From: Simon Davis
Sent: 19 January 2018 16:29
To: 'Raymond Cole'
Subject: Land at Kings Close, Yapton - Reserved Matters Application - Y/74/17/RES

PLOT 1 HOUSE PLANS

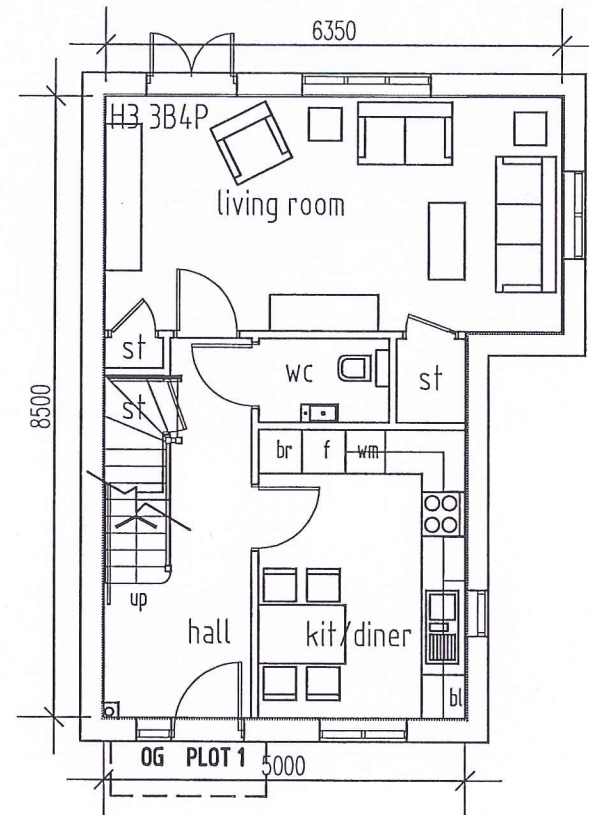
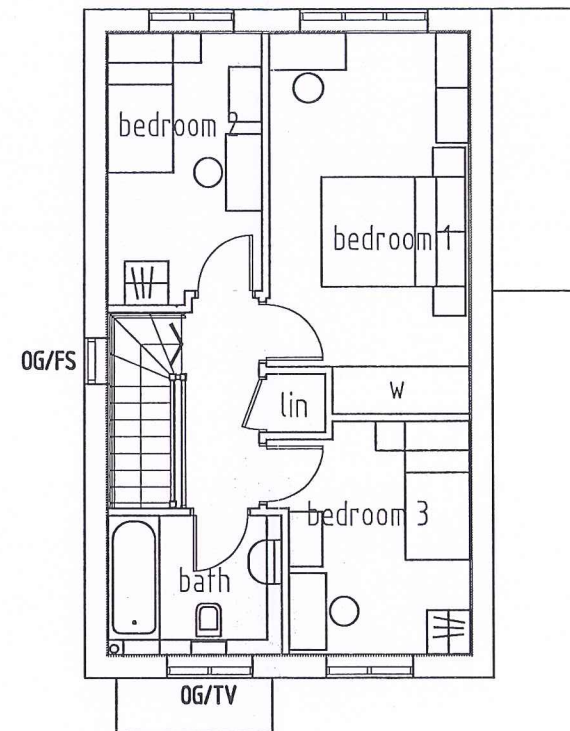
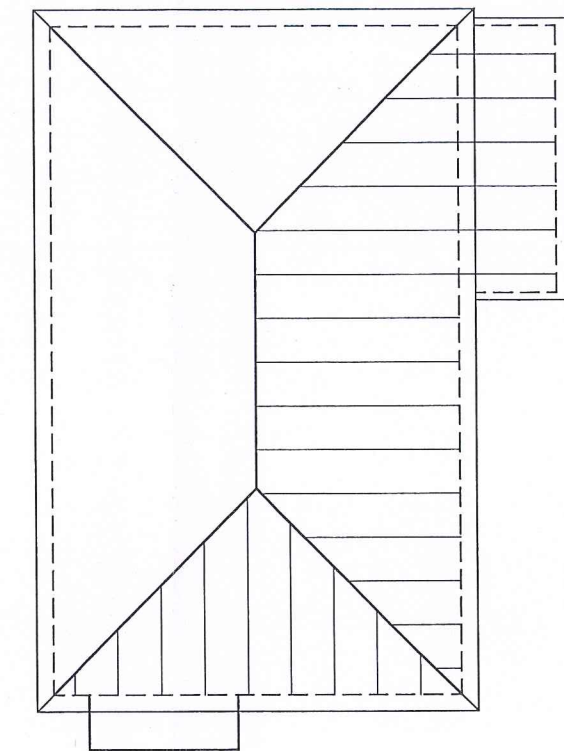
1. Is the FF window on the south elevation of plot 1 strictly necessary? It will face the front of Kingshaven at only 5m away. If so then this will need to be obscure glazed and fixed shut or top vent opening only. Could an amended plan be provided with this indicated.

PLOTS 9 - 11 HOUSE PLANS - SHEET 3

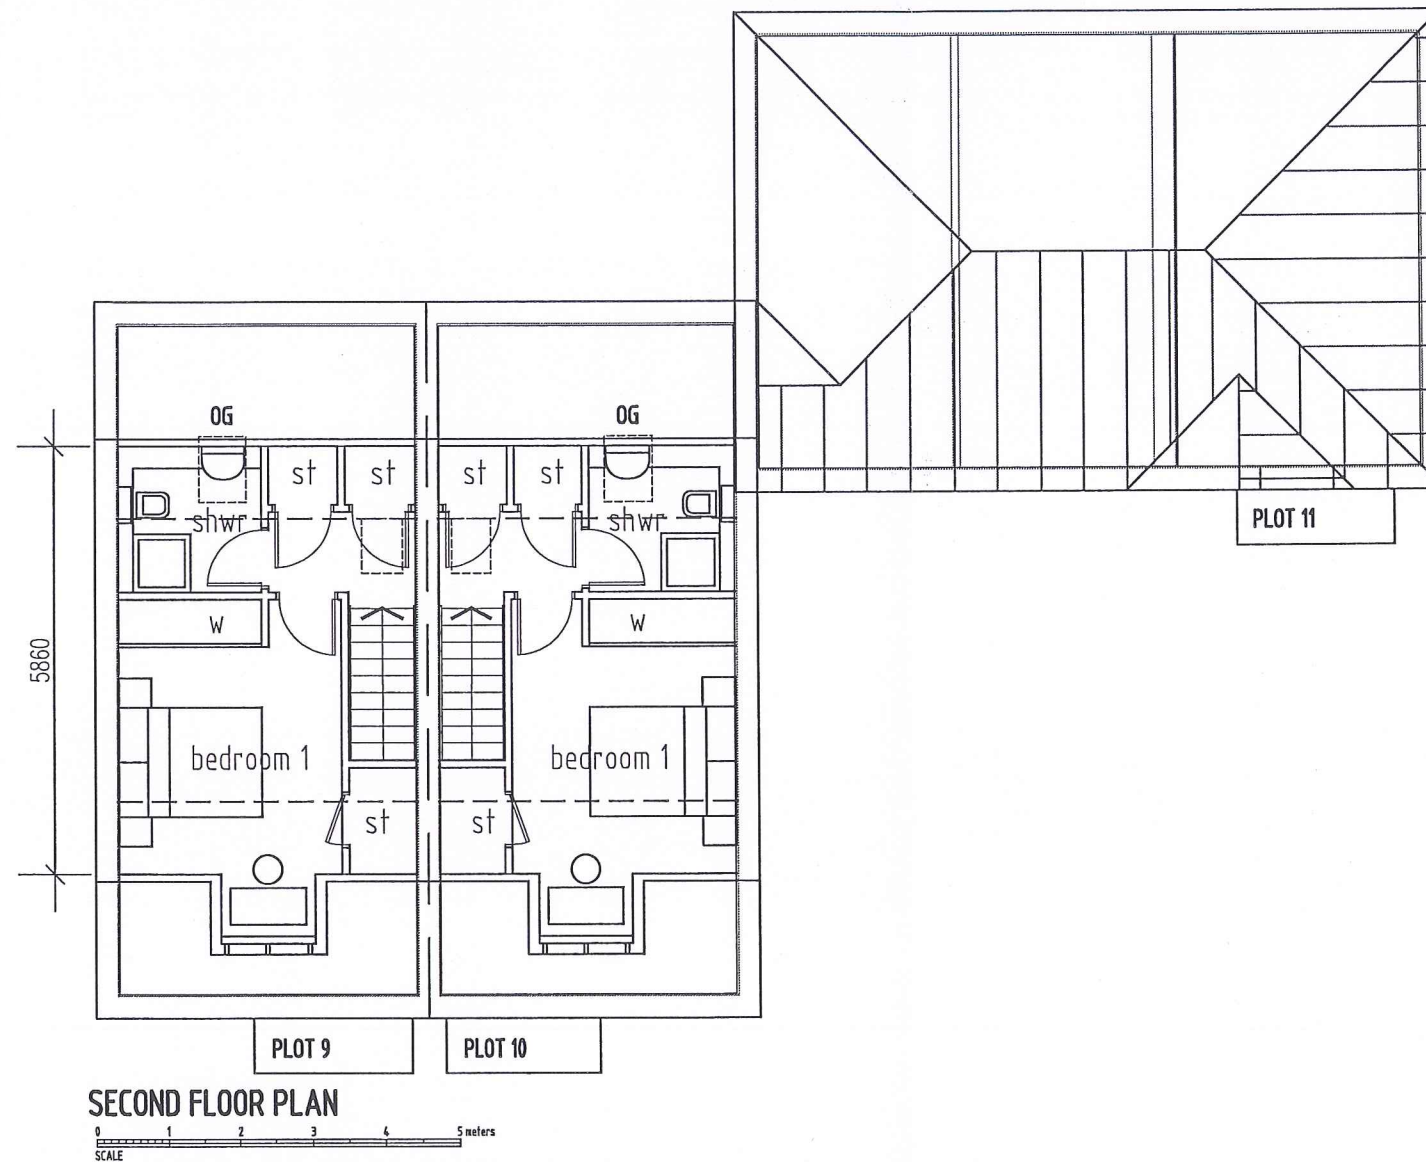
2. The FF window in the west elevation of plot 9 should be shown to be obscure glazed and with top vent opening only as otherwise it allows views of Connemara's rear garden. Could an amended plan be provided with this indicated.

3. The north elevation of plot 11 shows a kitchen window at FF which on plan is stated to be high level but isn't particularly so on the elevation. Can you clarify as I am concerned re overlooking of the FF lounge window on the S elevation of the existing flatted building.

4. The front (south) elevation of plot 11 is shown to have a solid brick wall at GF which looks odd. Is this supposed to represent the rear wall of the undercroft parking? If so then that is fine.

PLOTS 16 - 18 HOUSE PLANS - SHEET 2

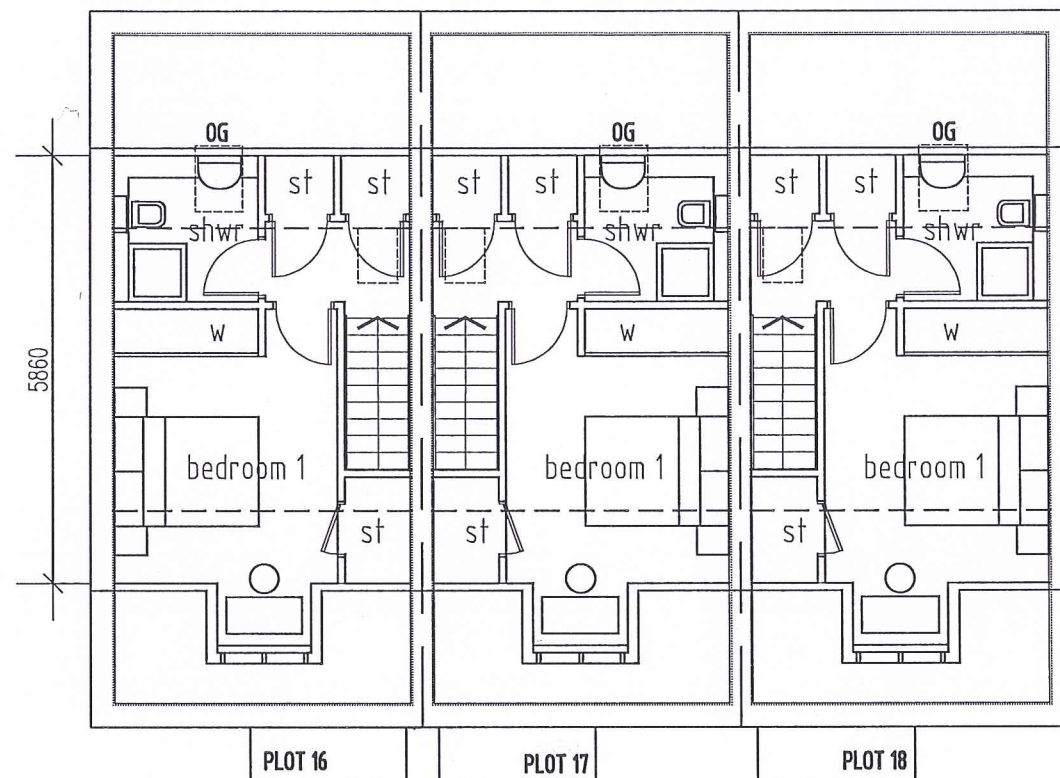
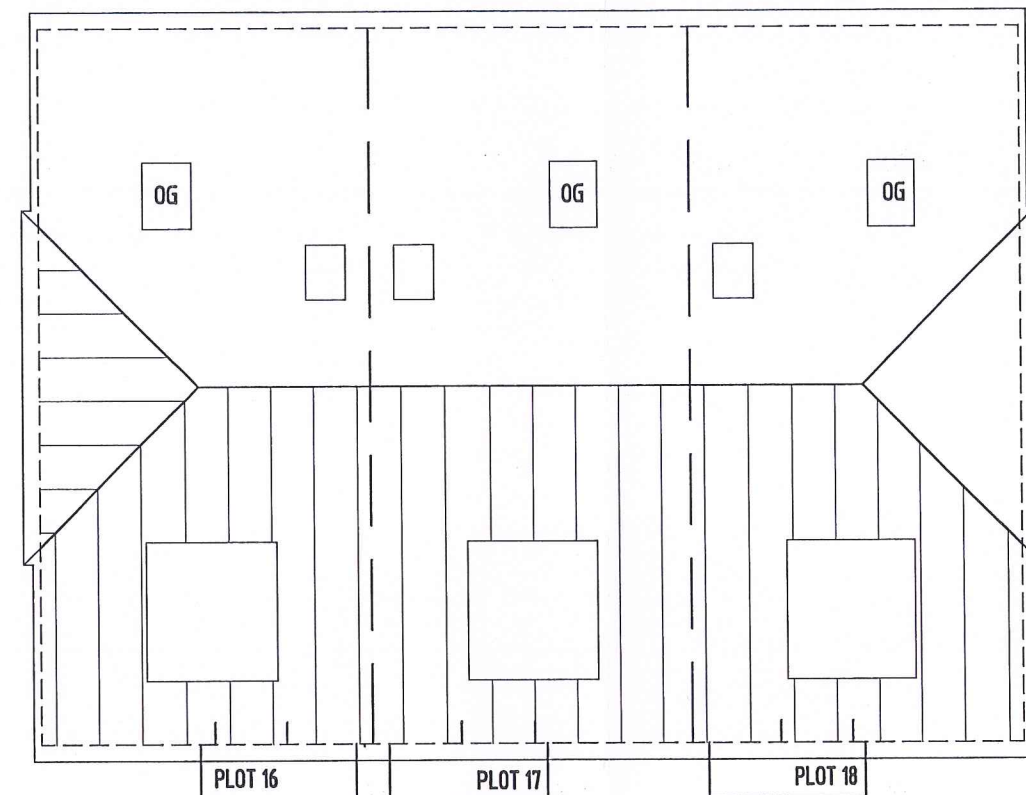
6. I have a concern re the interface between plots 14-15 and the eastern elevation of plot 16. The simplest way to resolve this would be to have the FF bathroom window in the eastern elevation off plot 16, obscure glazed and top vent opening only. Could an amended plan be provided with this indicated.
